From: Chris Moore [REDACTED]
Sent: 18 June 2020 [REDACTED]
To: Sian Eggington
Subject: RE: Request for further information BR/123/20/HH
Attachments: We sent you safe versions of your files; Prop Elevations 1.pdf

EXISTING ELEVATIONS

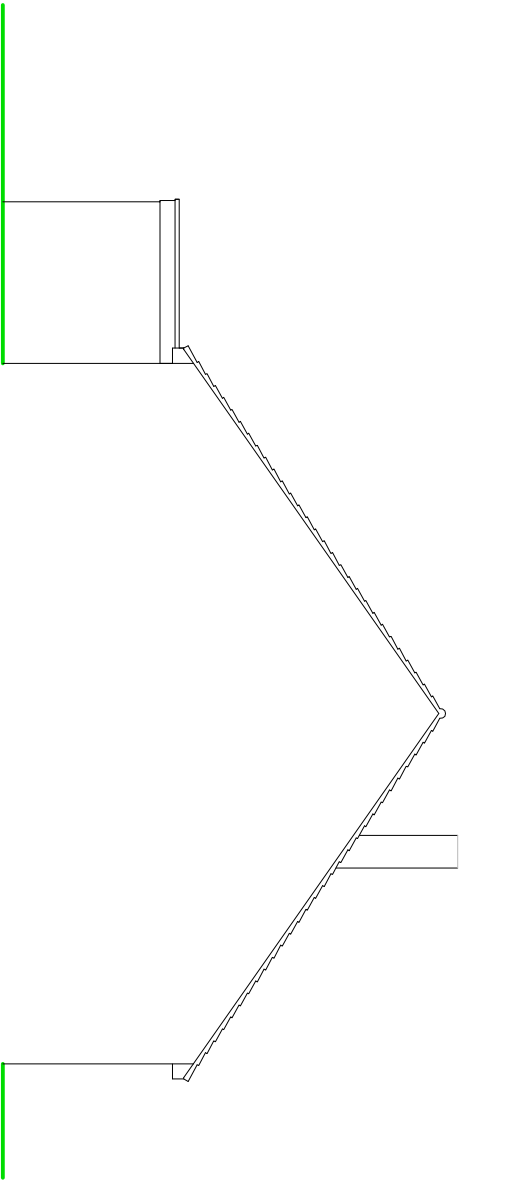
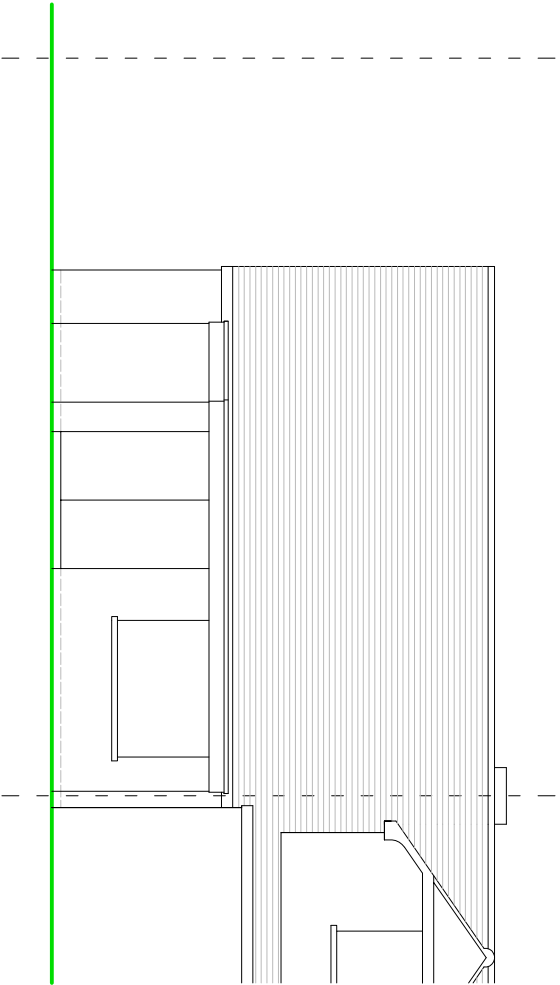
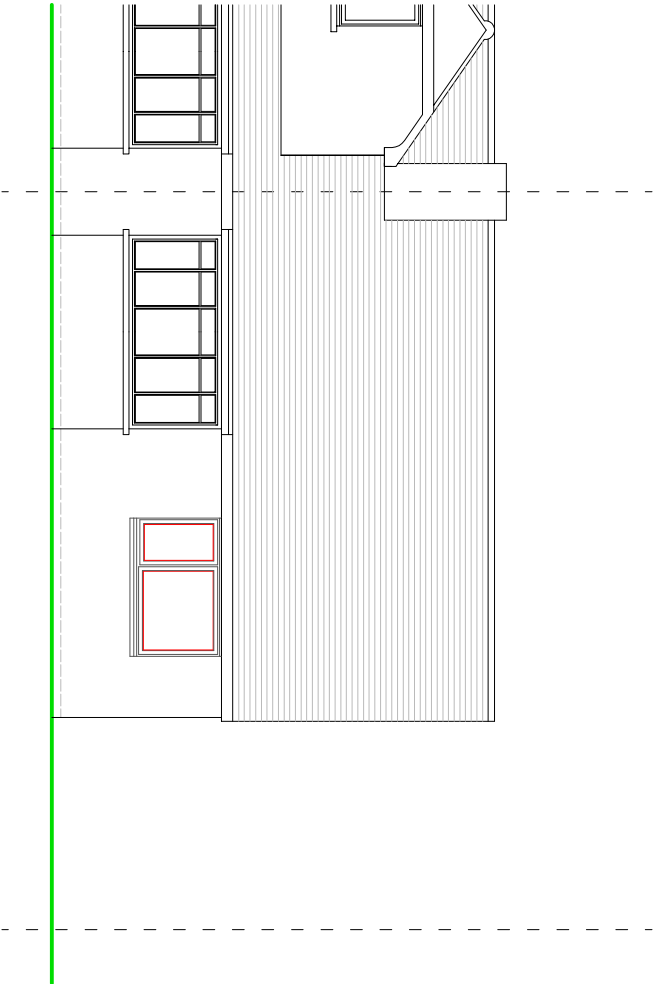
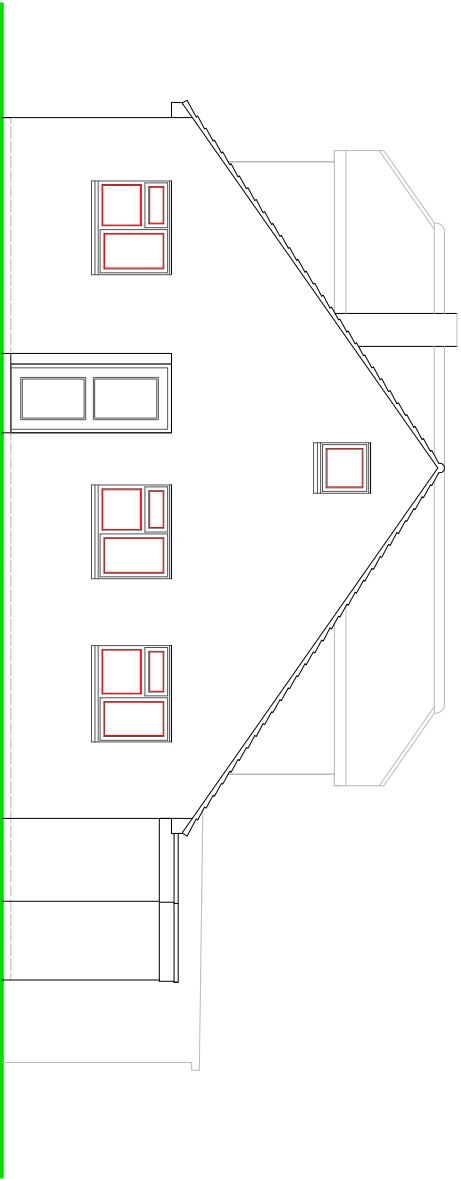
Confirmation Required: The existing side elevation is showing a dormer, please confirm whether this is showing a neighbours dormer. -- Yes, that is next door's dormer.

Thank you for your email, please confirm whether the dormer shown on the existing side elevation is a neighbouring dormer. The existing shower room on the ground floor is also being split into a WC/utility the floor plan shows this affects the window being split from one large window to 2 x small windows however this has not been shown on the proposed side elevation. Please amend.

PROPOSED ELEVATIONS

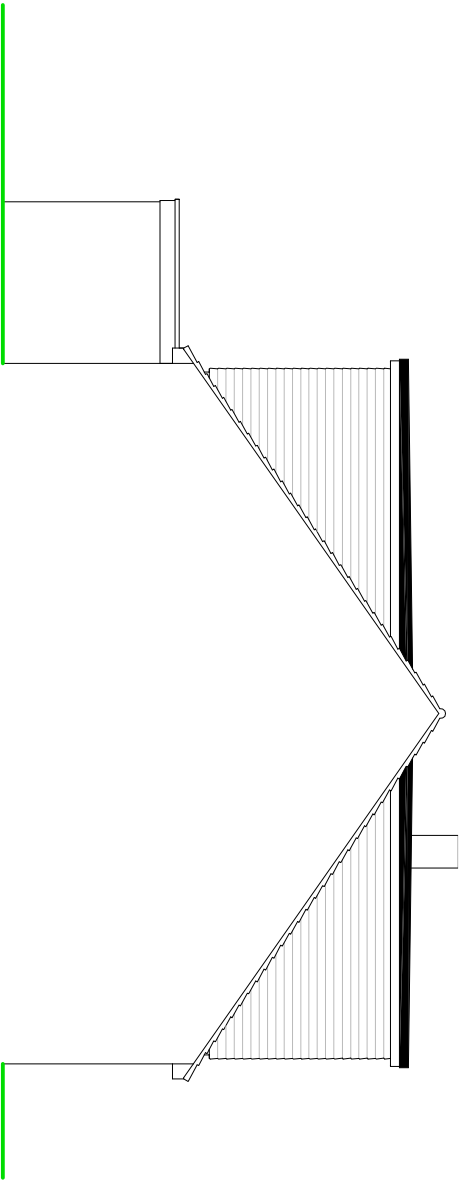
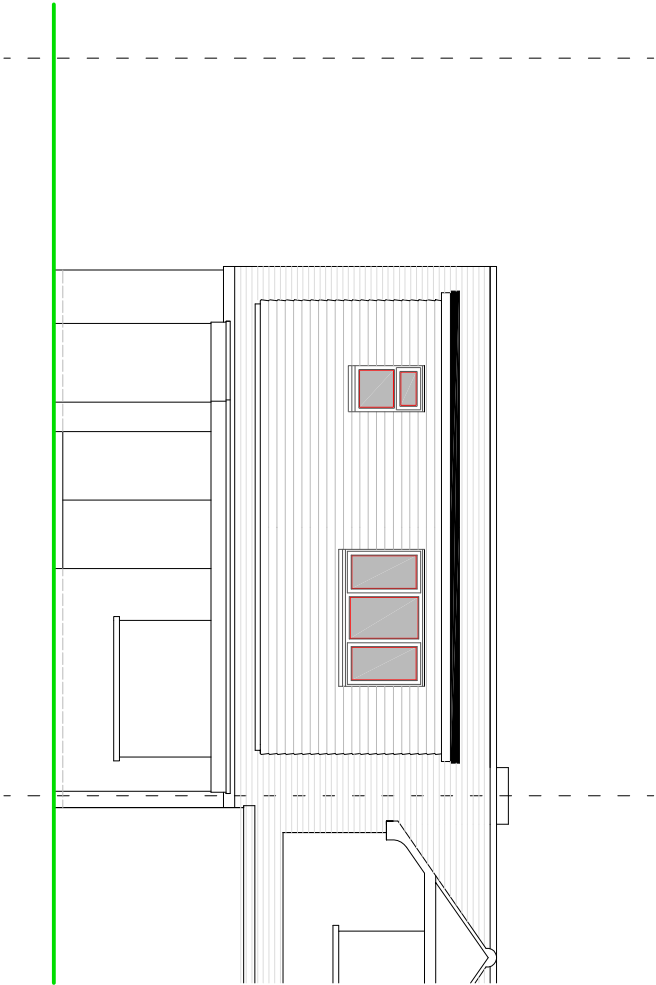
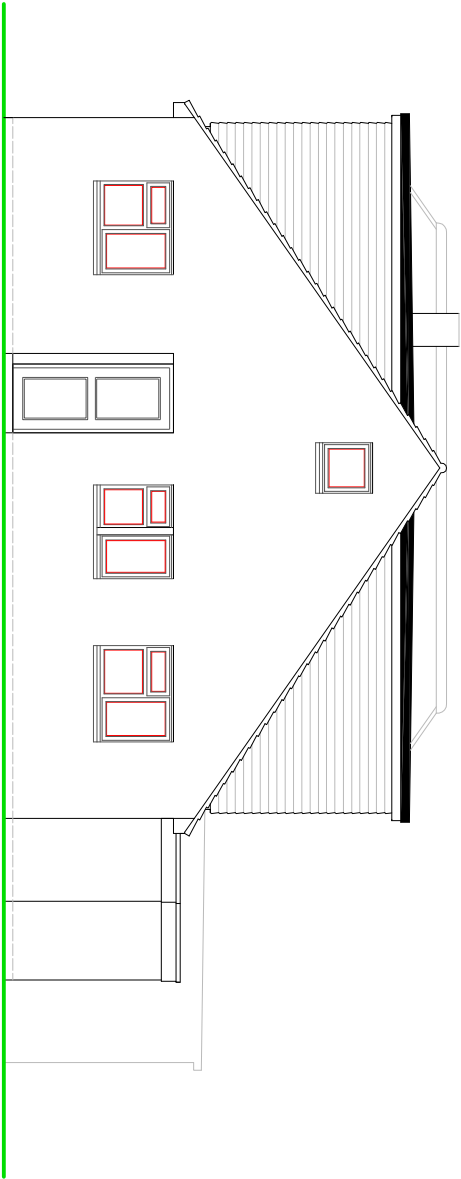
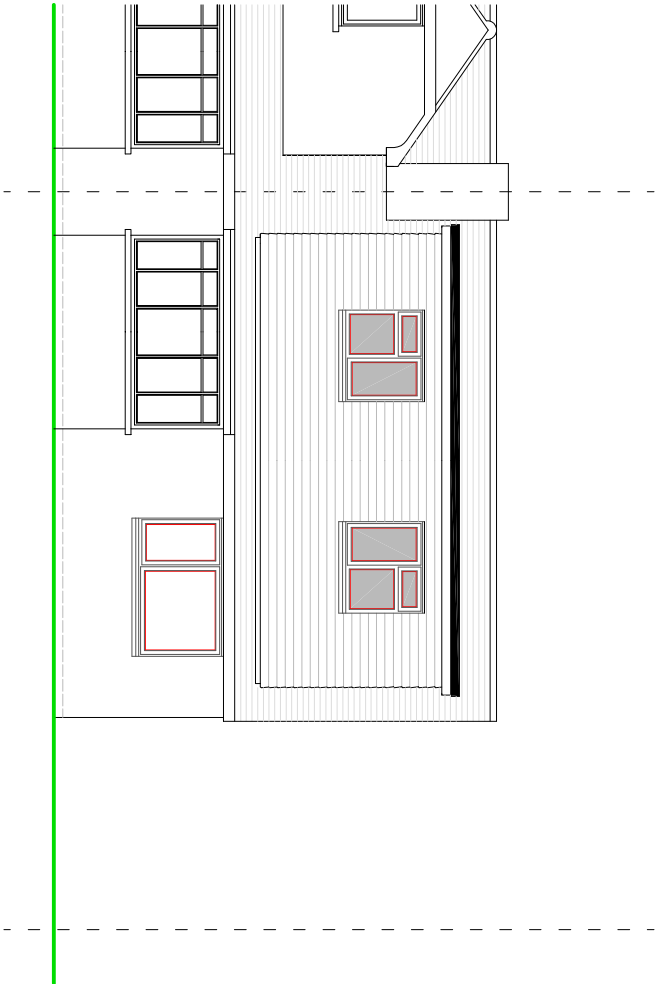
Plan: The windows are inconsistent between the proposed ground floor and side elevation. Please amend. -- windows adjusted on the attached elevation.
